Our Ref: A/02490

16th October 2025

Land North of Denby Lane, Grange Moor, Huddersfield - (KIRK) Discharge of details reserved by conditions 12 (drainage), 13 (storm events) and 15 (surface water attenuation) of previous permission 2024/92444 for erection of 21 dwellings and associated works with means of access from Denby Lane

JOB No	DRG No	REV
24017	101	O

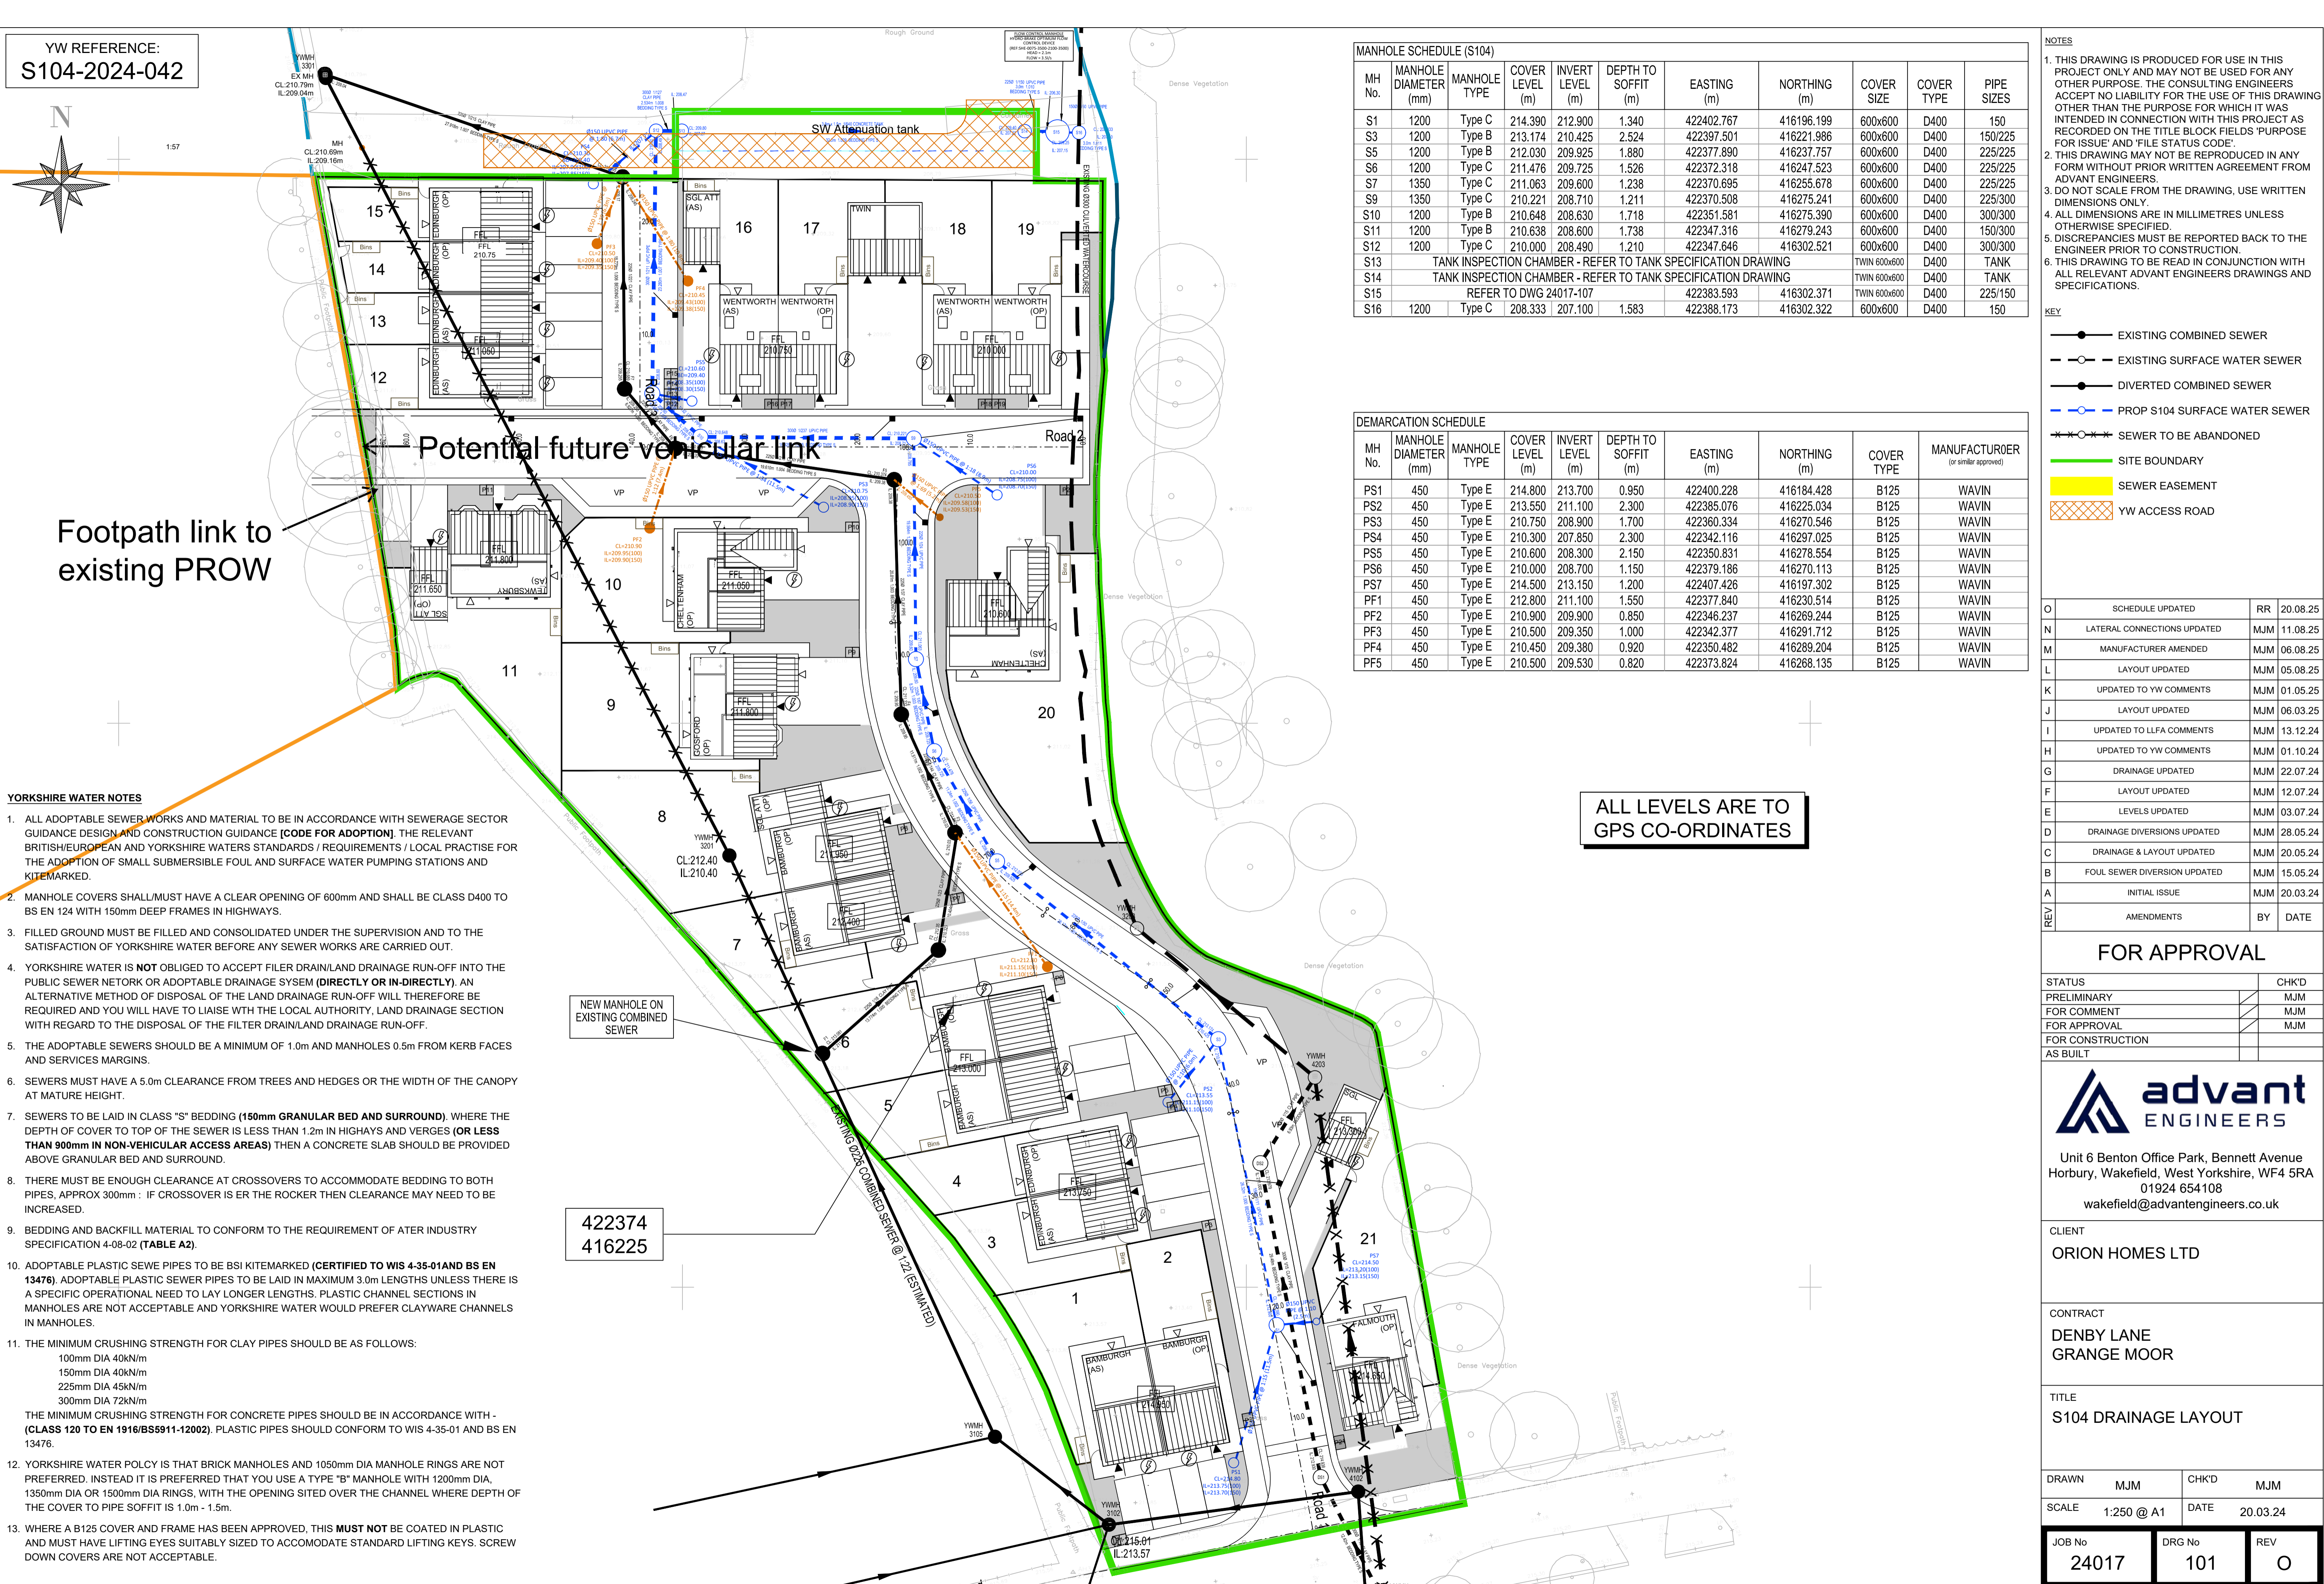
Yorkshire Water have no objection to the discharge of conditions 12 13 and 15.

- 1) The proposed sewer diversions (subject to the requirements of Section 185 Water Industry Act 1991).
- 2) The proposed building stand-off from public sewer centre-lines (of three metres)
- 3) The proposed separate systems of drainage on site and off site
- 4) The proposed amount of domestic foul water to be discharged to the public combined sewer network
- 5) The proposed points of discharge of foul water to the public combined sewer crossing the site

submitted on drawing 24017-101 (revision O) dated 20/08/2025 that has been prepared by Advant Engineers.

The submitted drawing shows surface water proposed to be drained to culverted watercourse at a restricted rate of 3.5 litres/second.

The developer should also note that the site drainage details submitted have not been approved for the purposes of adoption or diversion. If the developer wishes to have the sewers included in a sewer adoption/diversion agreement with Yorkshire Water (under Sections 104 and 185 of the Water Industry Act 1991), they should contact our Developer Services Team (tel 0345 120 84 82, email: technical.sewerage@yorkshirewater.co.uk) at the earliest opportunity. Sewers intended for adoption and diversion should be designed and constructed in accordance with the WRc publication 'Sewers for Adoption - a design and construction guide for developers' 6th Edition, as supplemented by Yorkshire Water's requirements.
